From: Ian Stocks [REDACTED] **On Behalf Of** FRS Water and Access
Sent: 04 November 2021 15:04
To: Planning.Responses <Planning.Responses@arun.gov.uk>
Subject: Planning consultation - EP/125/21/PL 22 Vermont Drive East Preston BN16 1LA

Having viewed the plans for planning application No. EP/125/21/PL, evidence is required to show adequate access is provided for a fire appliance to reach the new property and a suitable turning facility is provided to ensure the appliance can turn and make an exit. The access route says it is made up of a gravel driveway, evidence will be required to show the gravel track will be capable of supporting 12.5 to 18 Tonne axial weight of a fire appliance to ensure access can be gained to within 45 metres of all parts of the dwelling.

Fig 4. Proposed Site Layout

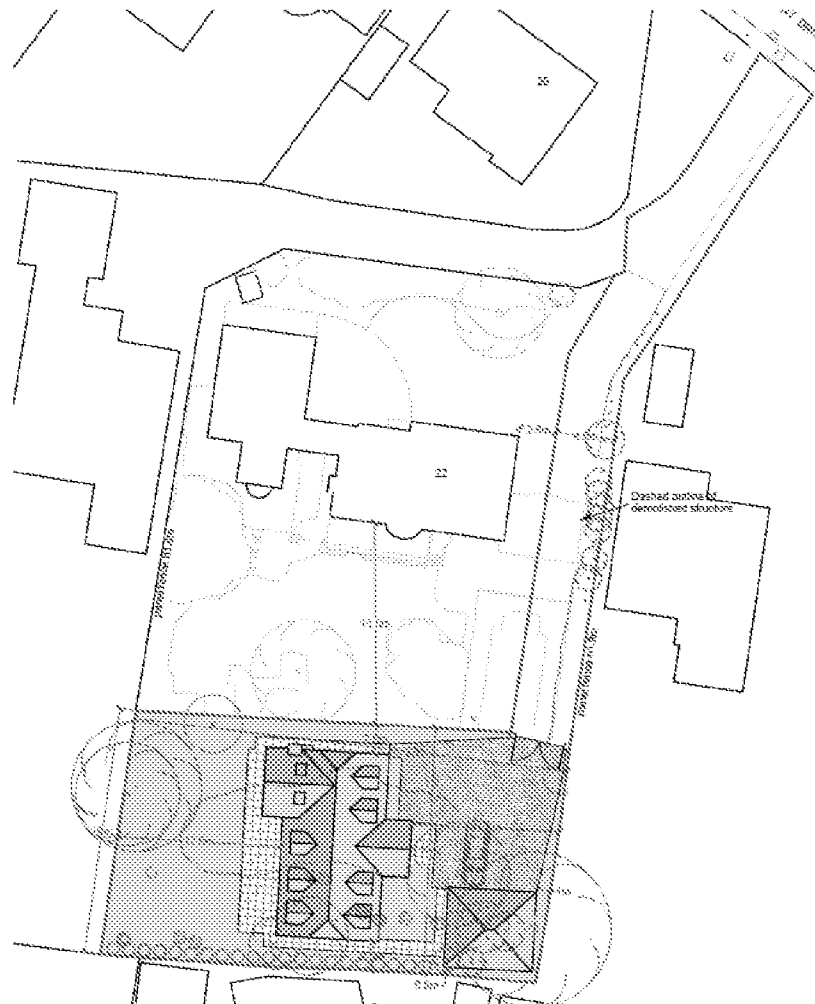
A fire appliance should not have to reverse than 20 metres to make an exit, from the plans submitted it is not clear a turning facility has been provided. these issues identified are a requirement of Approved Document - B: Volume 2 - 2019 Edition B5 section 15 for Fire Service Access, including Table 15.2 for dimensions required.

Without these requirements being met the Fire Service would not be capable of attending the site with a fire appliance in the event of a fire or any other emergency, any areas not within

45 metres of a fire appliance will need to be mitigated by the installation of domestic sprinkler or water mist system complying with BS9251 or BS8458 standards.
